**CITY OF ALBUQUERQUE
PLANNING DEPARTMENT
August 1, 2012
DRB Comments**

ITEM # 15

PROJECT # 1009355

RE: Lot 28, Alvarado Gardens, Unit 1

A1 SITE PLAN - PROPOSED PROPERTY LINE
SCALE: 1/8"=1'-0"

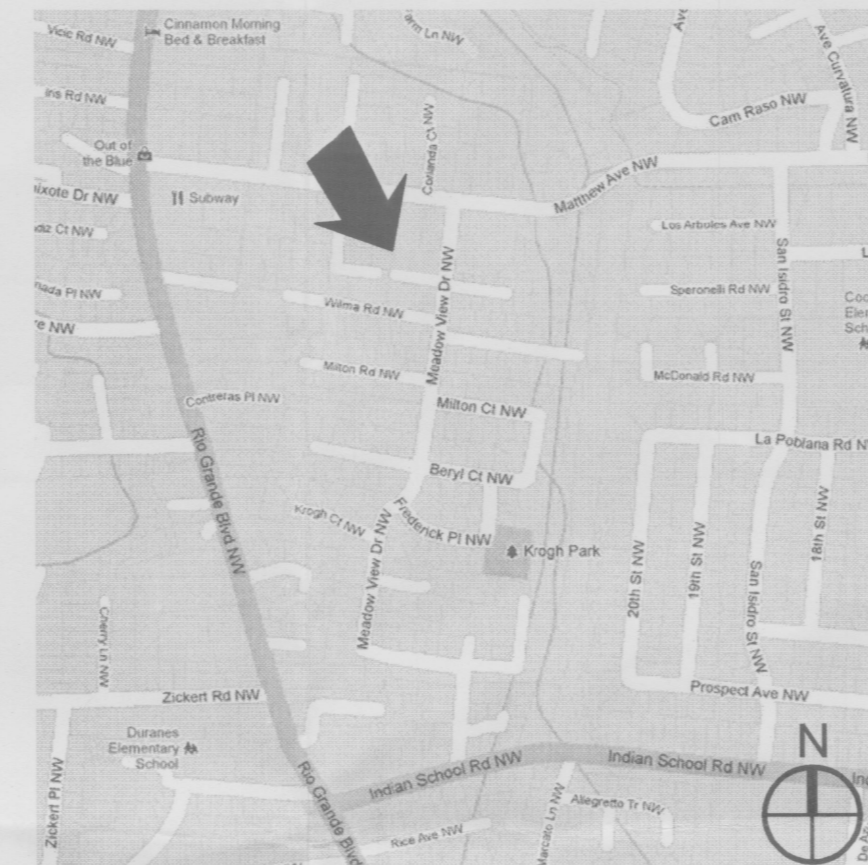
The proposal is for a "portion of" Lot 28 – the creation of this portion prior to the adoption of the current Subdivision Ordinance (1973) must be documented by deed, otherwise all of Lot 28 would need to be included in the plat. Creation of Covina Place as a private road must also be documented, to include access rights.

It appears several subdivision design variances would be required from the maximum number of lots and the maximum length of a stub street, as well as no sidewalk; refer to comments from Transportation Development.
